REQUEST

Current Zoning: R-6MF(CD) (multi-family residential, conditional)
Proposed Zoning: UR-2(CD) (urban residential, conditional)

Approximately 0.30 acres located on the south side of Hoskins Road and west side of Gossett Avenue.

The petition proposes to adaptively reuse the existing building onsite with six multi-family dwelling units at a density of 20 units per acre. The site was originally an accessory building to Hoskins Mill.

RZ-1

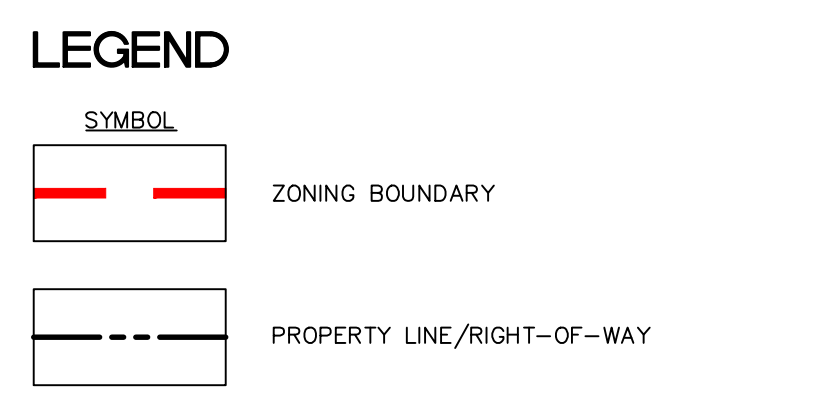
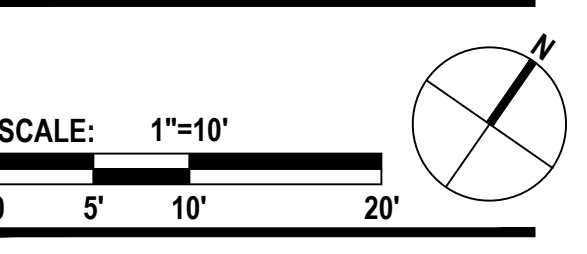
- ~~1. Please provide dimensions for the existing sidewalk along Gossett Ave. The existing sidewalk must be a minimum of 6' to be used for UR zoning.~~ **ADDRESSED**
